**PROPOSED MODIFICATION OF THE MIXED DEVELOPMENT USE AT NO. 157**  
**REDFERN STREET, REDFERN**  
**MP 09 0039 MOD 1**

To determine a modification request for the mixed development project approval (MP09\_0039 MOD 1).

Level 13 (Residential)

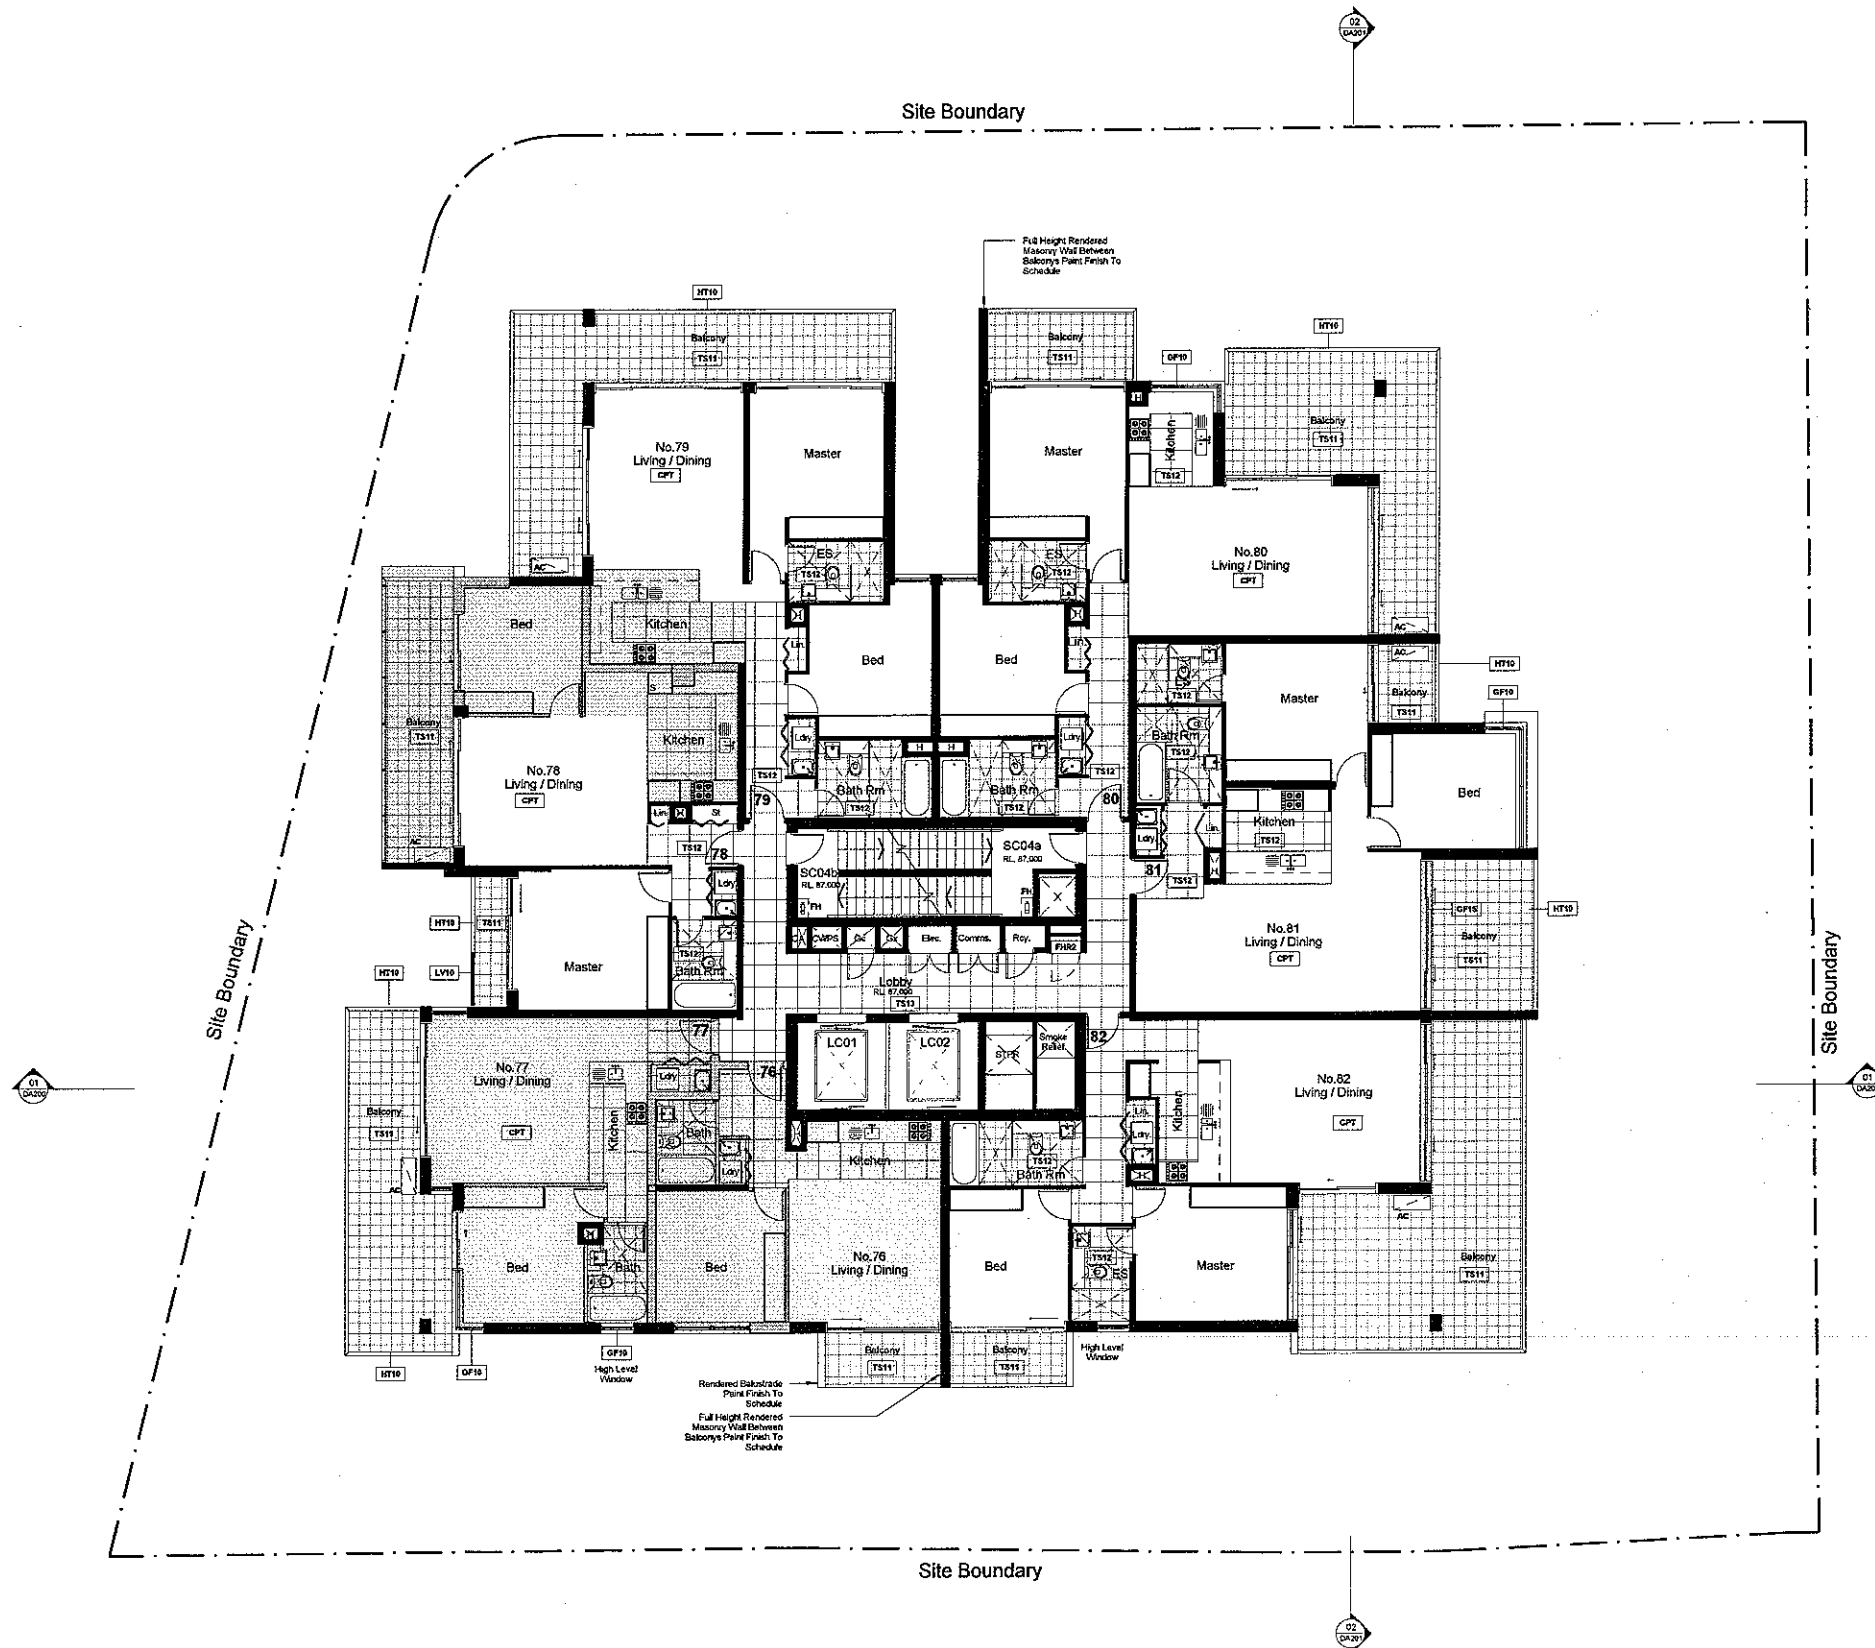
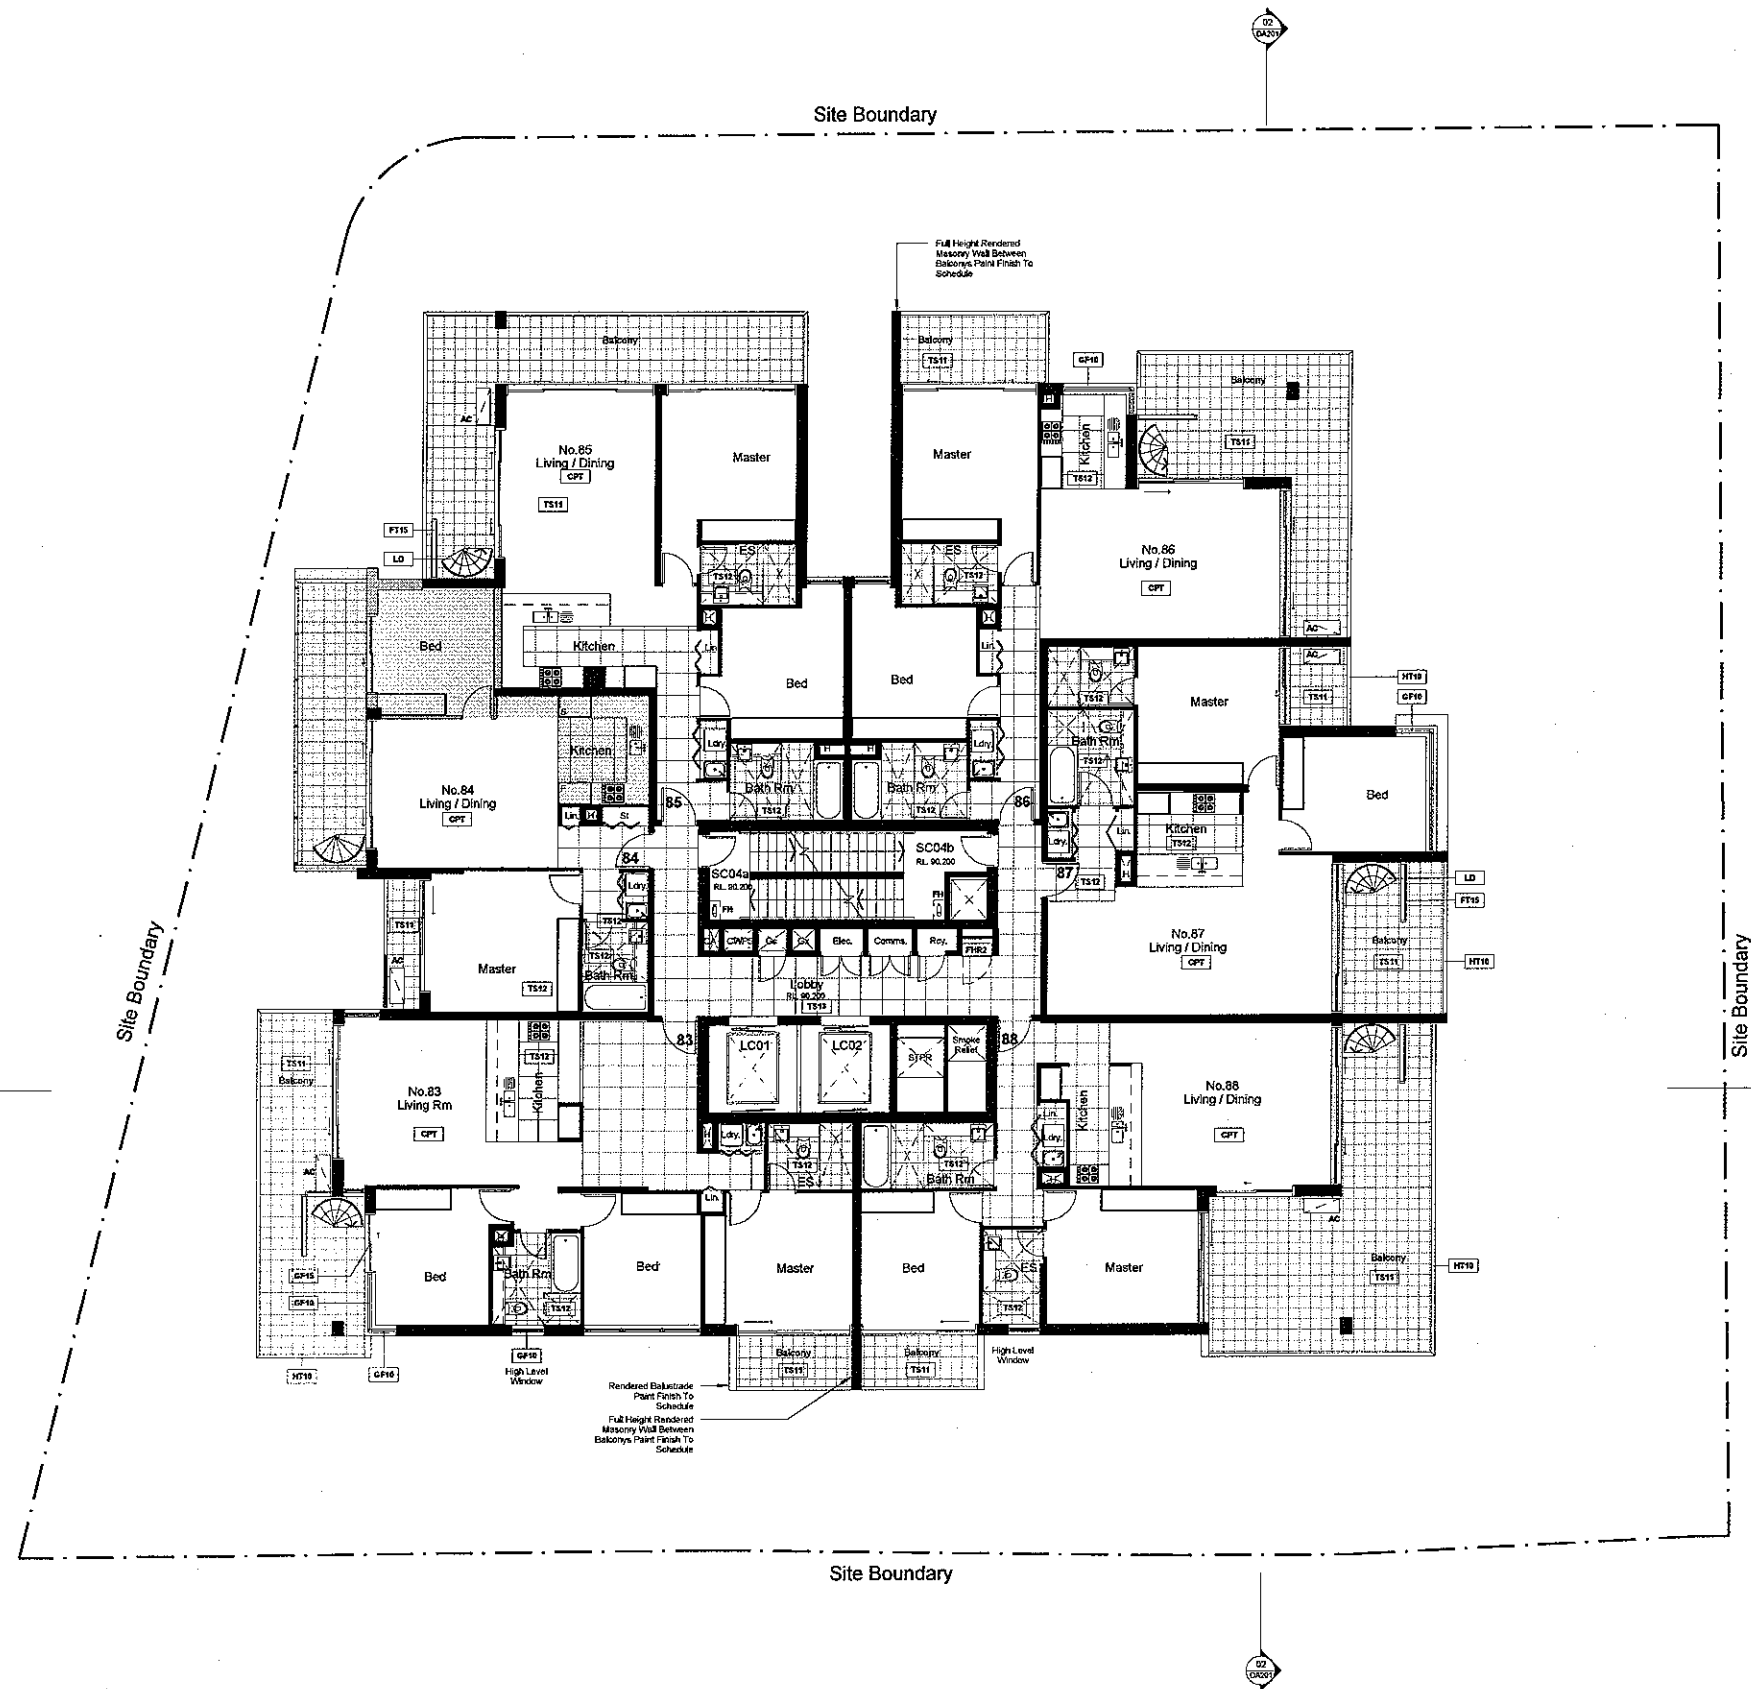
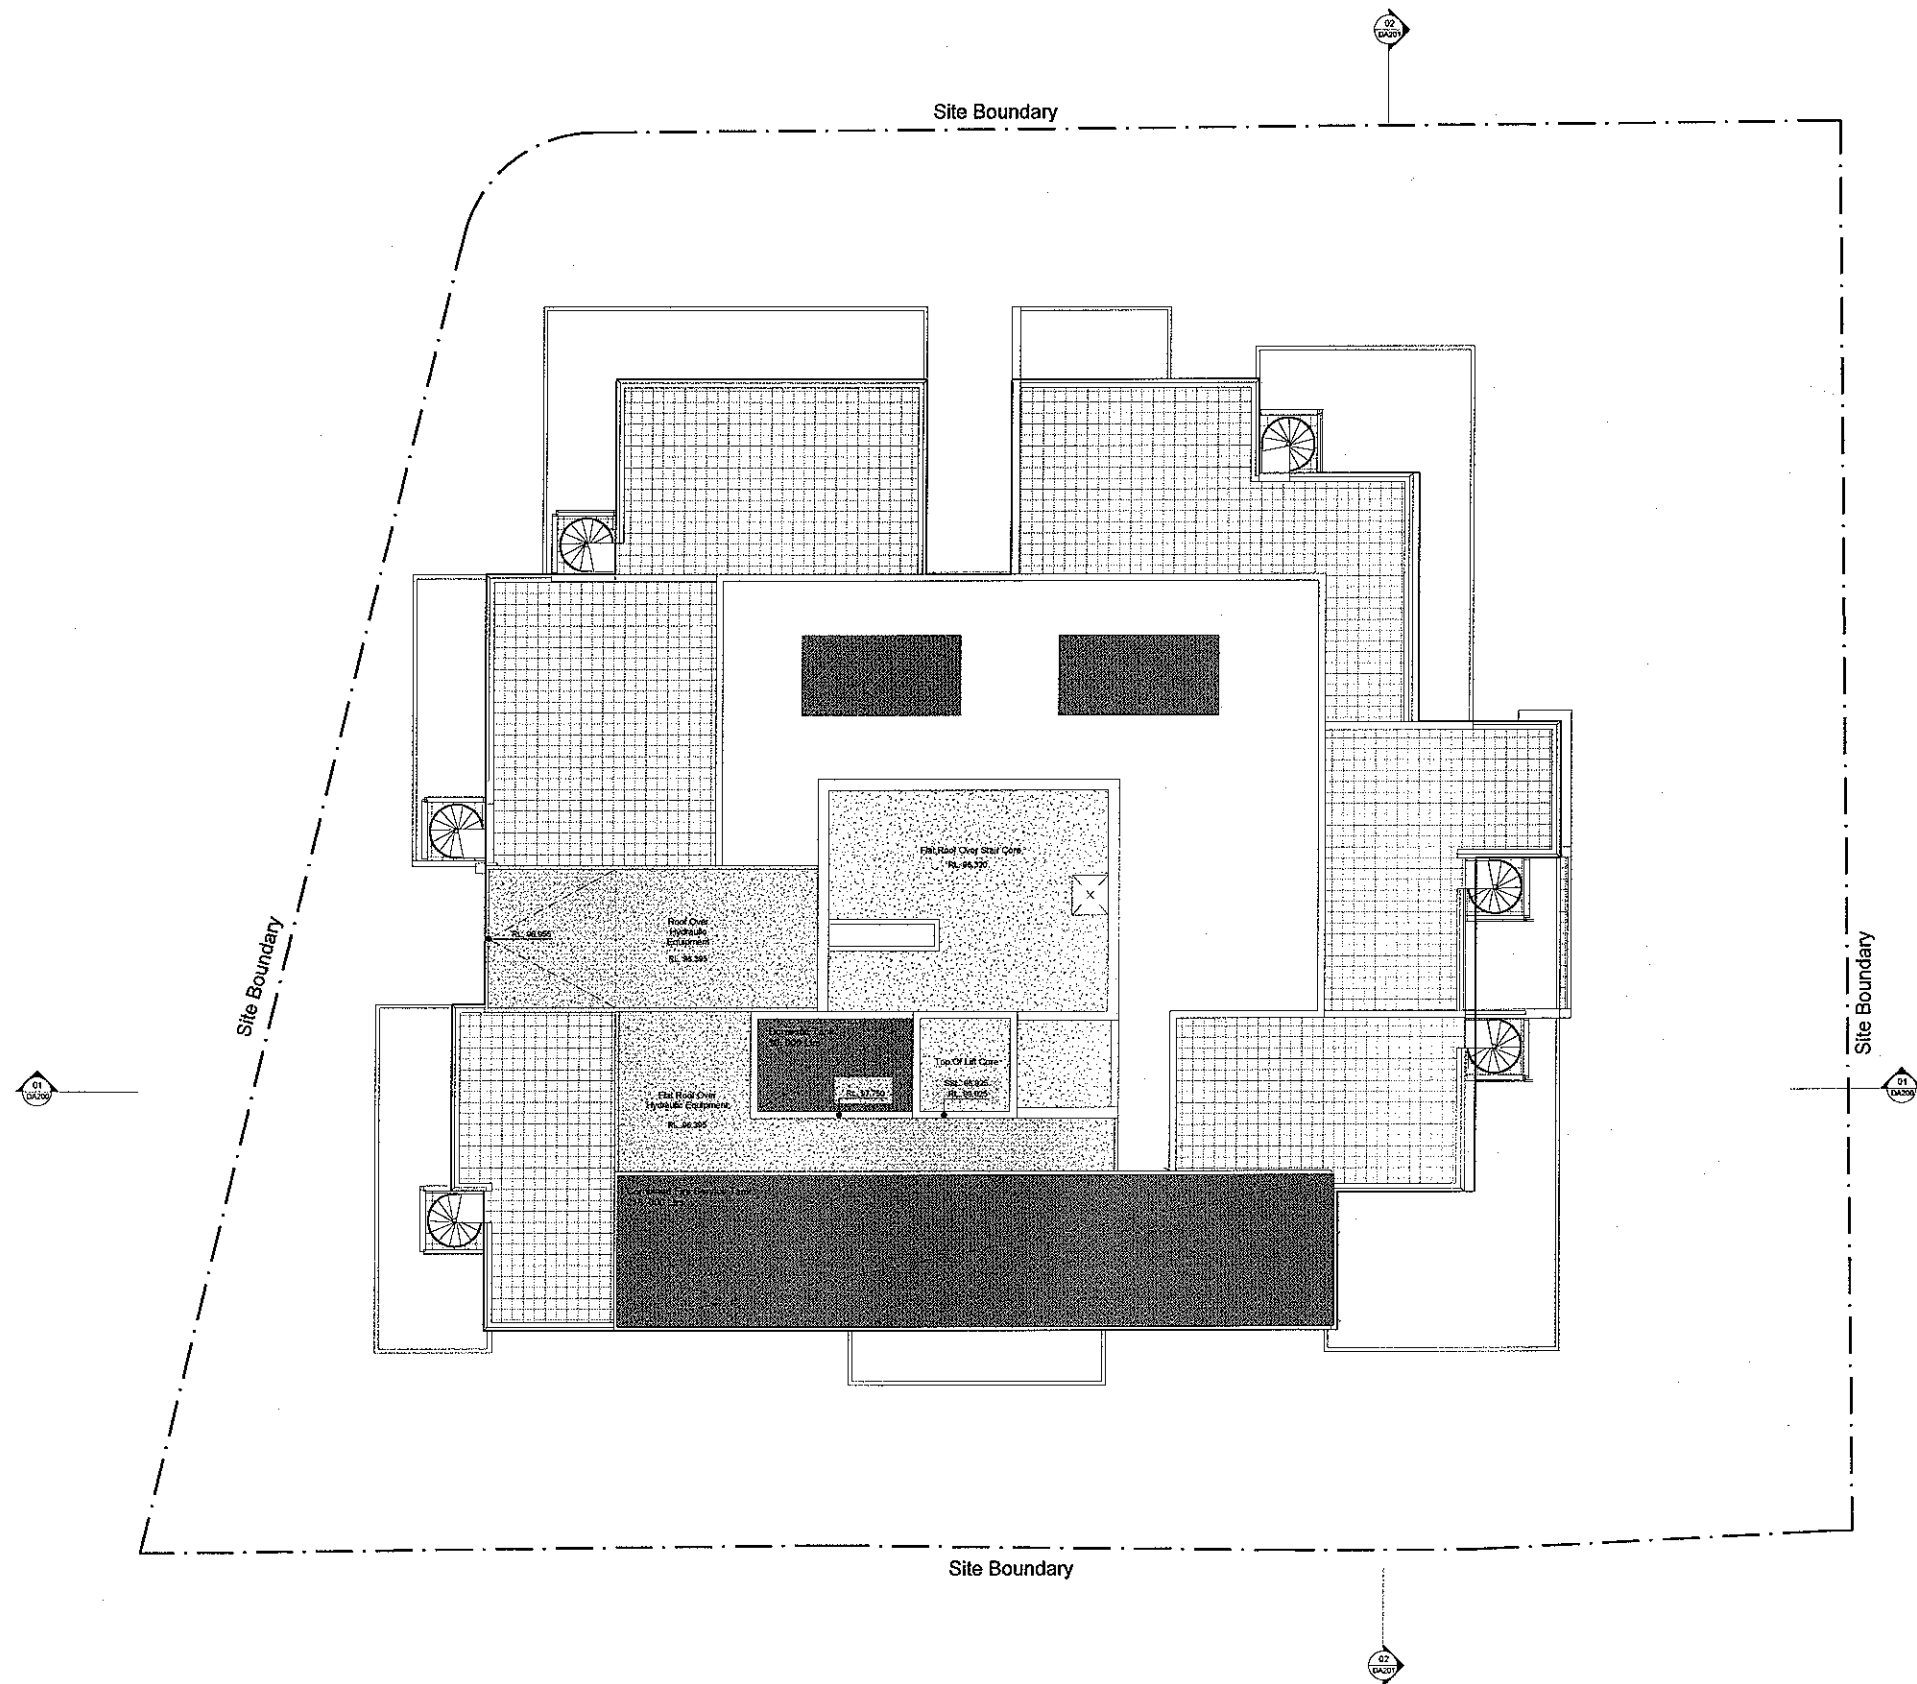
The RWA raised issue with the reduced boundary setbacks along Gibbons Street at the upper floor levels, no revised Wind Impact Assessment and that the intended reconfigured apartments are not capable of satisfying the minimum size requirements contained in the Residential Flat Building Code.

The City of Sydney Council objected to the non-compliance with the required 8.0 metre Gibbons Street boundary setback, noting that the Draft Redfern Centre Guidelines, recently exhibited in late 2010 requires a 4 metre setback from Gibbons Street. Furthermore, the

Council raised concern to the conversion of balconies to bedrooms, their internal size and that the current Wind Impact Study has not been amended to reflect the building changes.

The proponent submits that the modifications proposed involve the following non-compliant reductions in the approved building's setbacks from Gibbons Street at levels 13 to 18:

- the setback of the main wall of the building is to be reduced from a minimum of 3.67m in the area where the balconies are to be enclosed, to 2.585m; and
- the setback of balconies is to be reduced from 2.585m to 0.82m.

The reduced setbacks are to occur only on parts of five (5) levels of the approved building, namely levels 13 to 18, with the underside of level 13 being some 44m above the footpath level in Gibbons Street (western elevation). The area in which the setback is to be reduced is to have an elevational area of 168m<sup>2</sup> in the western elevation, which has an overall area of 1,996m<sup>2</sup>. This represents some 8.4% of the building's western elevation (refer to **Figure 2** and **3**).

The Department is satisfied that, although the setbacks proposed are non-compliant, the setback encroachment at the upper levels 13 to 18 positively contributes the visual horizontal and vertical modulation of the western elevation without any detrimental impact on the streetscape or adjoining buildings.
